17 February 2015

**SUBMISSION ON BARANGAROO FERRY HUB (SSI 6727)**

Clare Hall  
**Planning Manager – Barangaroo South**  
Lend Lease (Millers Point) Pty Limited

**Figure 1-1 Barangaroo Ferry Hub key proposal features (Indicative only, subject to design development).**

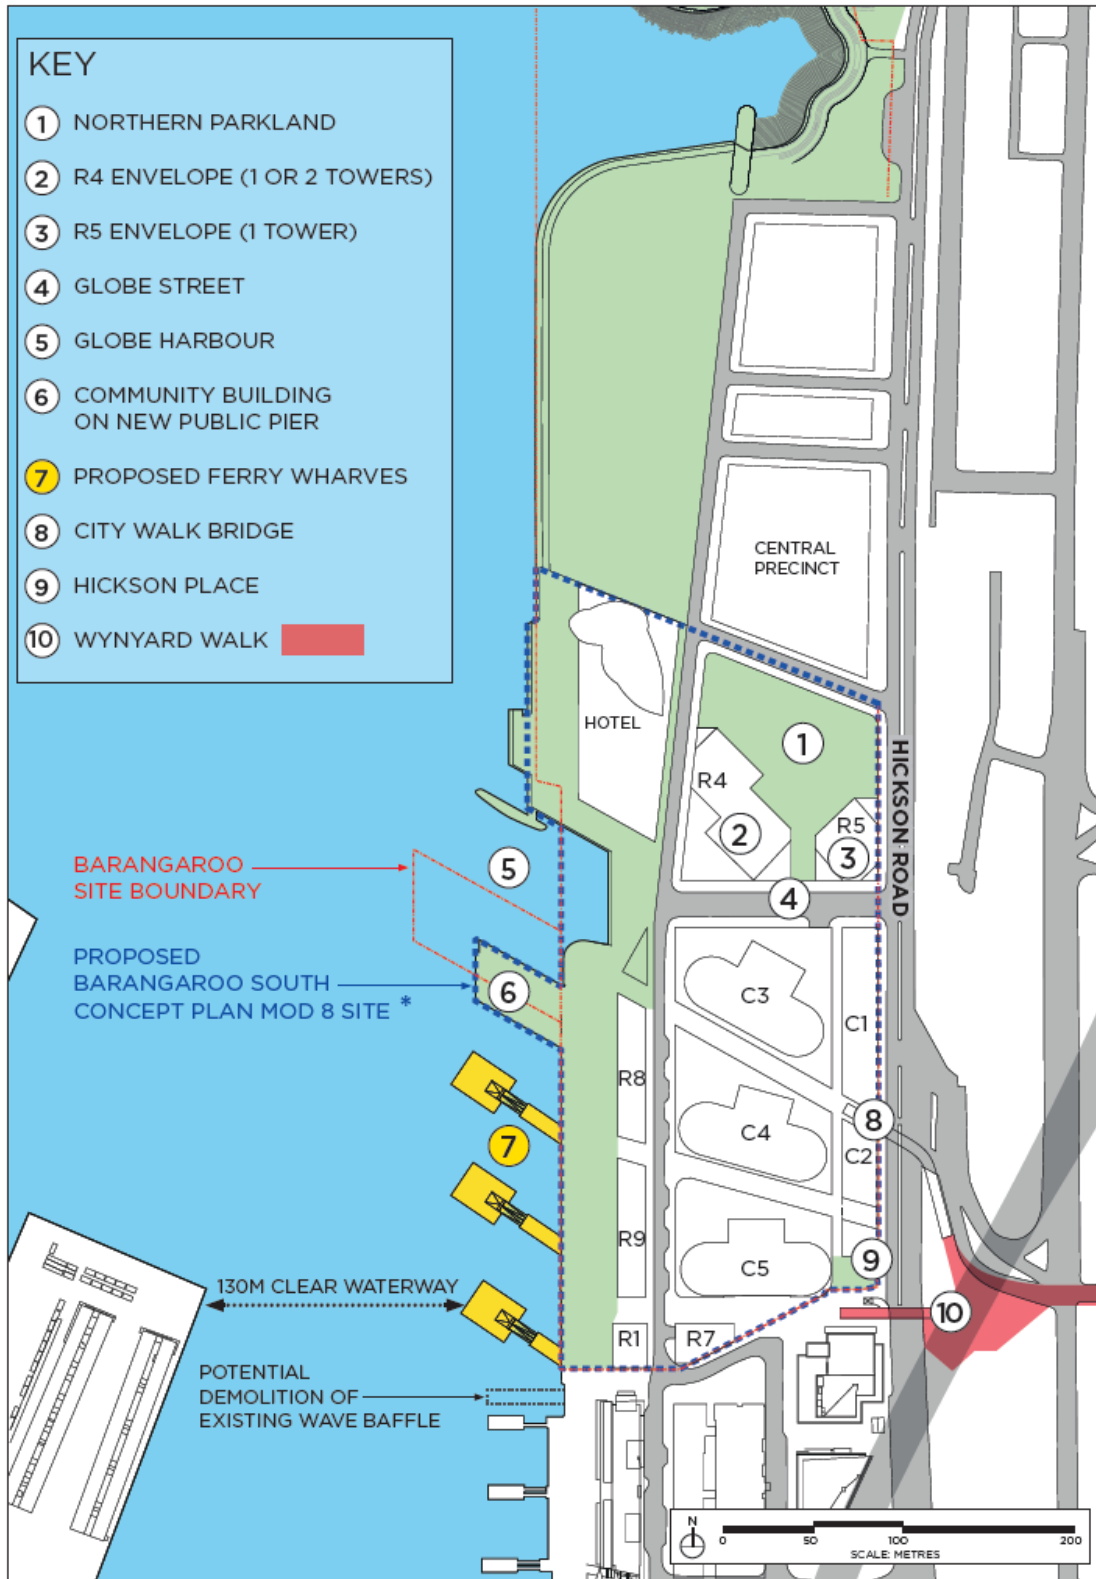
The proposed northern wharf appears to be very close to the pier that is envisaged under the approved Barangaroo Concept Plan MOD 7, and even closer under the positioning of the pier proposed in Concept Plan MOD 8 (see Request for Director General's Requirements). Specifically in this respect, Concept Plan MOD 8 proposes the relocation of the former hotel pier southwards in order to both accommodate the proposed Crown Hotel and maintain a consistent width of the Southern Cove. The relationship between the existing and proposed piers and the ferry wharves should be examined and the operational safety of both items ensured.
